From: Ancy Sagayanathan
Sent: 23 January 2024 16:30
To: Planning Online
Subject: Consultation for Application Ref No APP/2023/2357

Consultee: Flood Risk and Coast Protection
Planning Reference: APP/2023/2357

**Full Planning Permission for Erection of 4 Storage Sheds (Class 6) at Site To South Of Muirhead House,
Muiryheadless Road, Inch Business Park, Inch, AB52 6TS**
Grid Reference: 363331.828872
Reason for Consultation: Planning Authority seeking Flood Risk Advice

Site Plan  
Scale 1:200

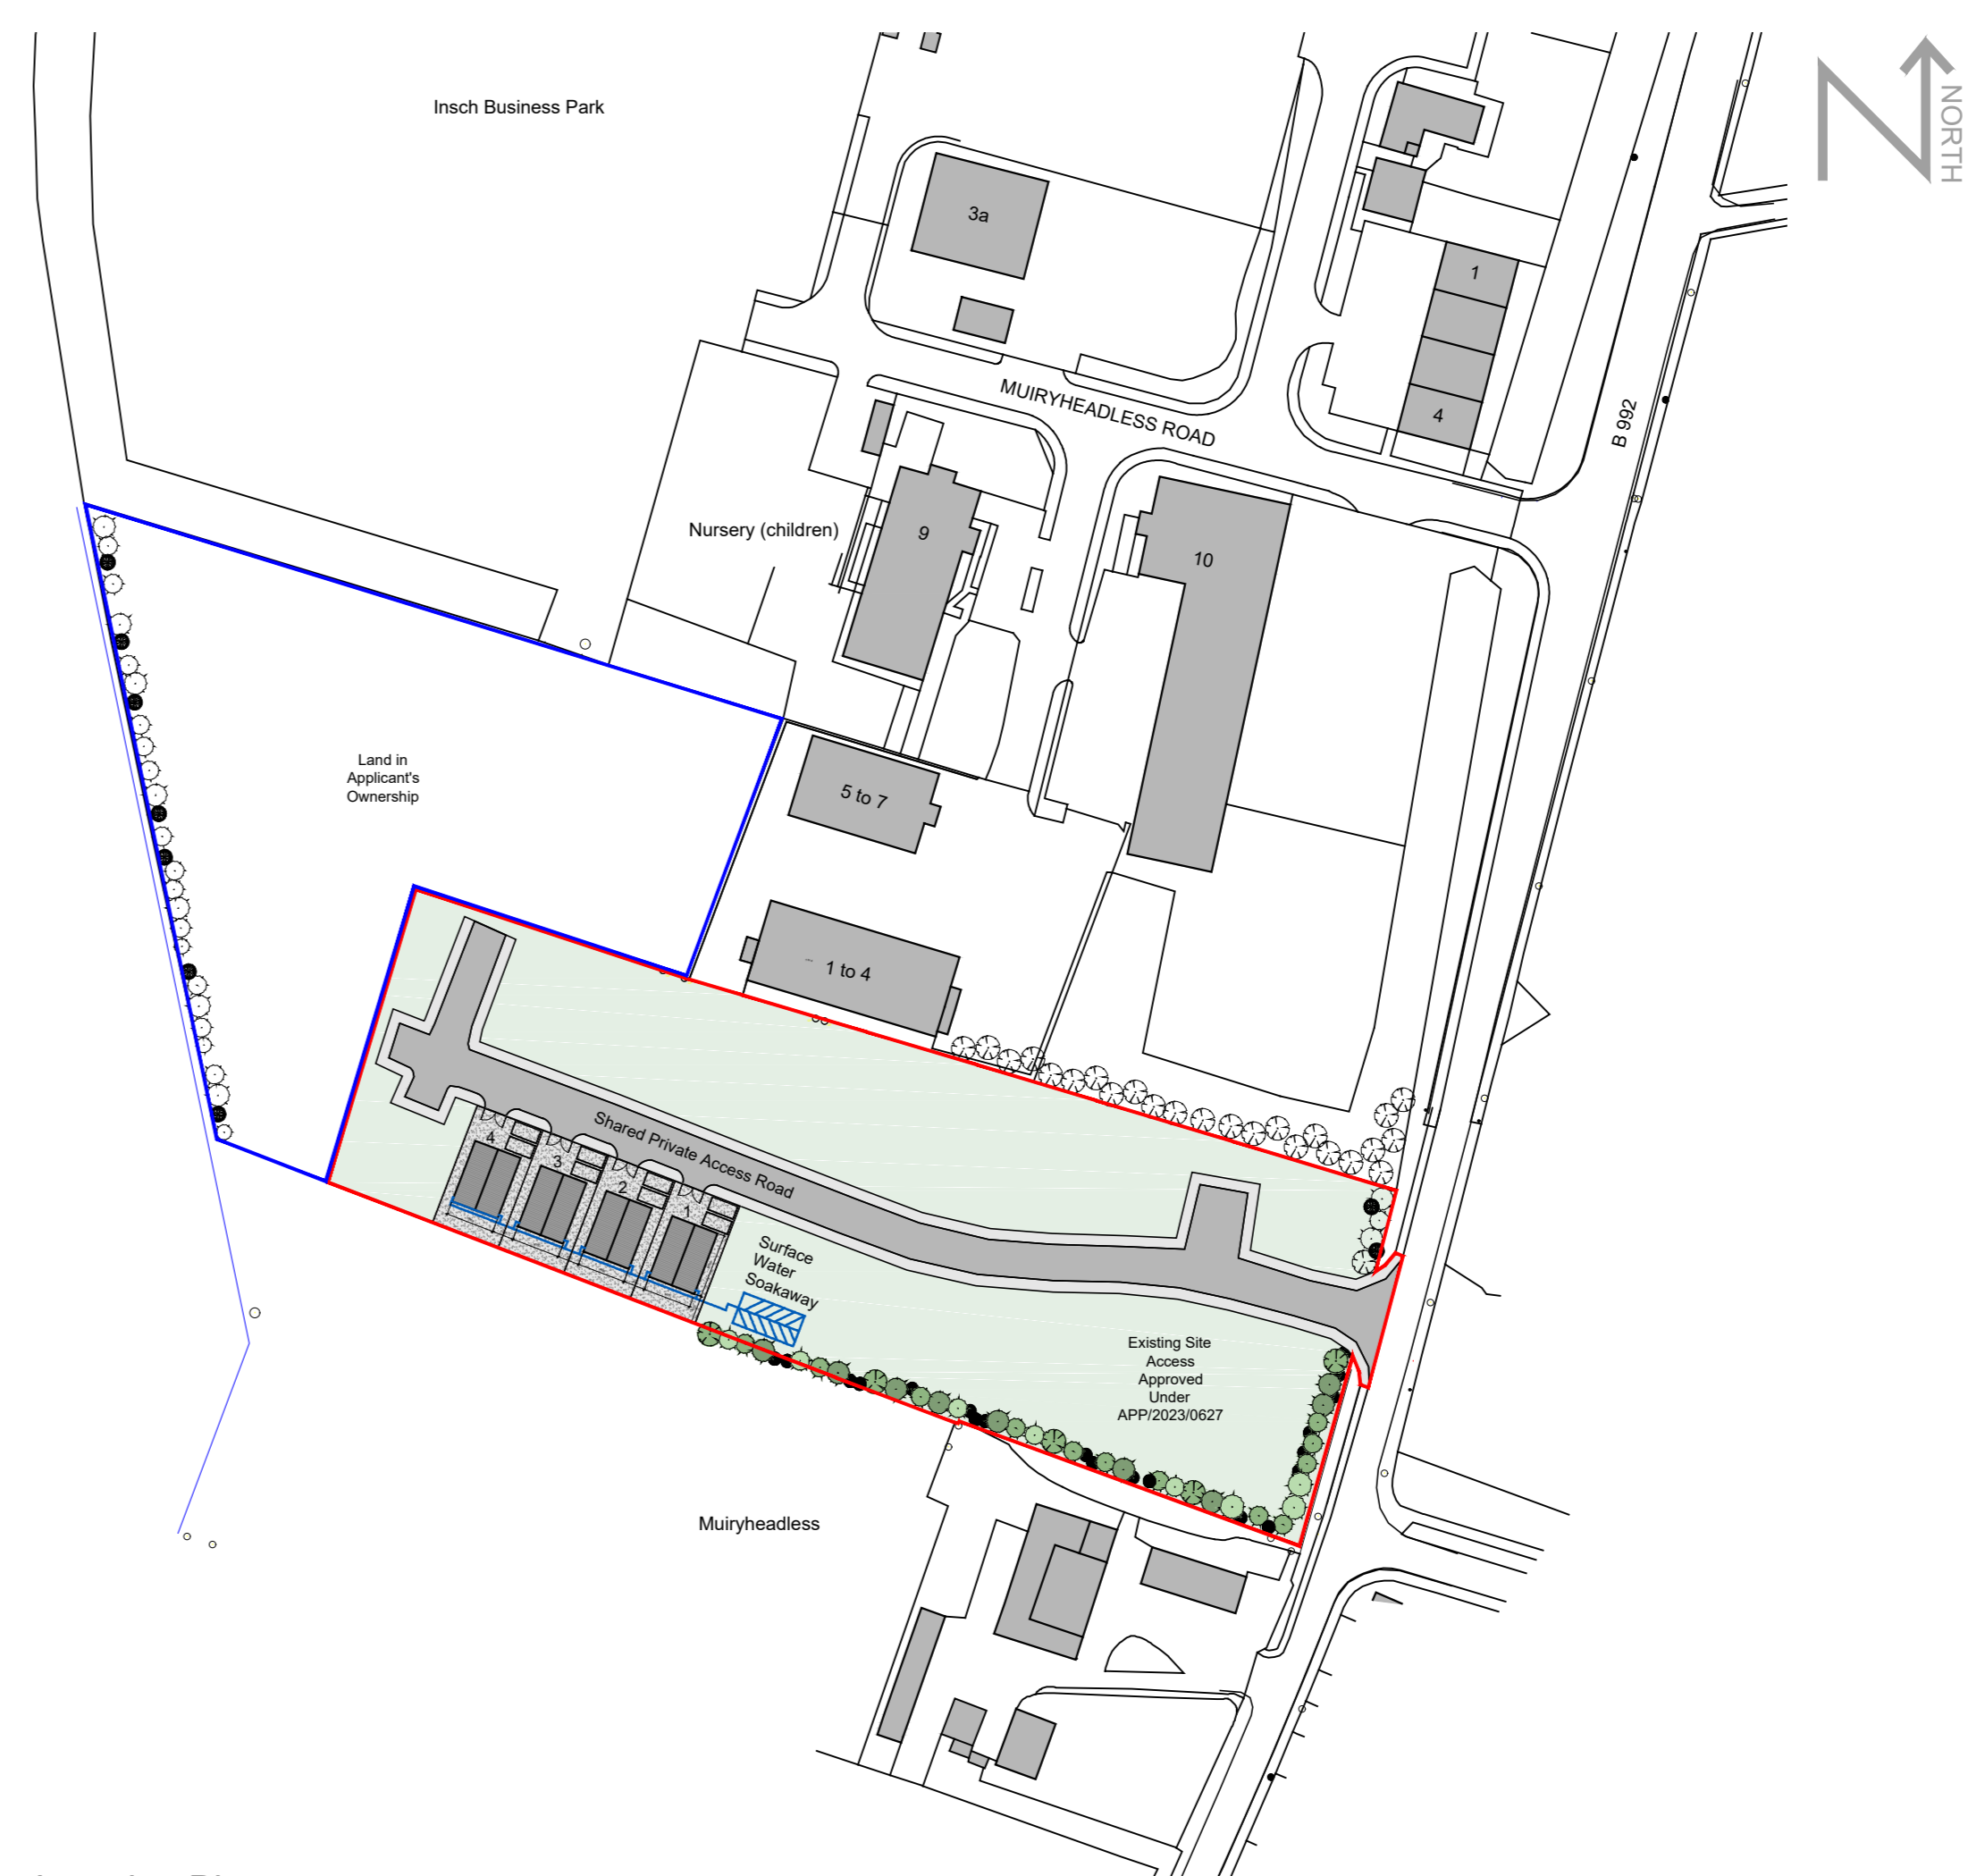
It has been observed that there is a field drain to the west of the site, which is not identified as a risk on the flood maps. However, while it is not possible to completely eliminate the risk of flooding, it is advisable to incorporate flood-resistant materials during the development.
